22/12/2021

**Luddenham Resource Recovery Facility (SSD-10446)
Request for additional information**

I refer to Response to Request for Information (RFI) dated 14 December 2021 for the Luddenham Resource Recovery Facility (SSD-10446). After careful consideration, the Department is requesting that you provide additional information.

PROJECT TITLE	TURNING MOVEMENTS PLAN
SHEET 1 OF 2	
PROJECT NO.	7472-CD
DRAWING NO.	021
DATE	B

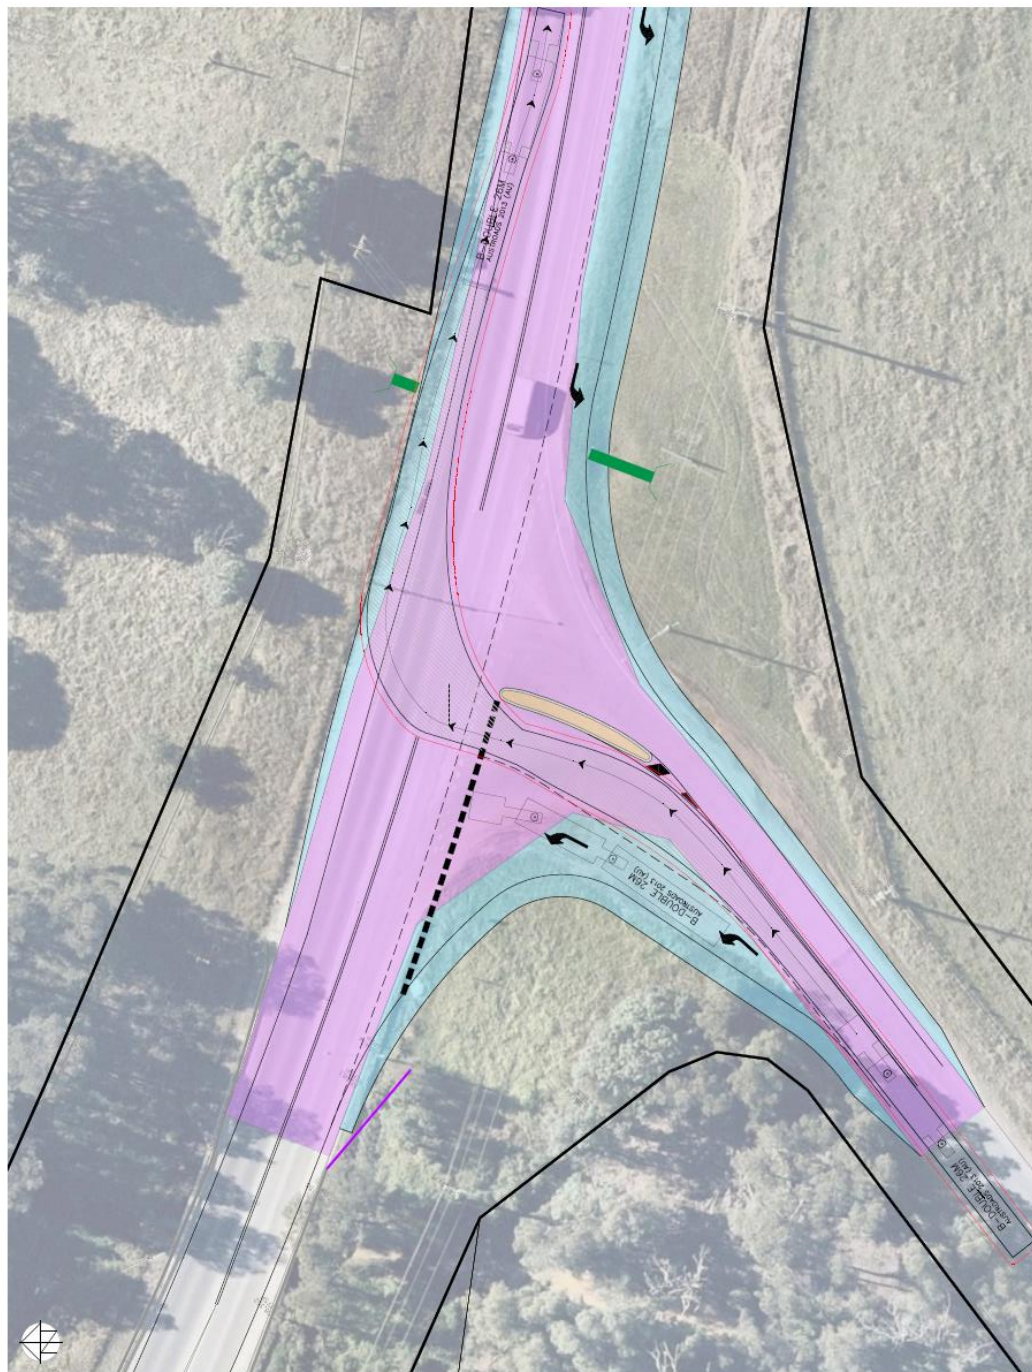
2. Transport for NSW noted road design for the junction upgrade between Elizabeth Drive and Adams Road discourages heavy vehicle from turning left into Adams Road Elizabeth Drive. It is requested the Applicant investigate transport options in consultation with key stakeholders to ensure heavy vehicles associated with the proposed development can be accommodated by the surrounding road network.
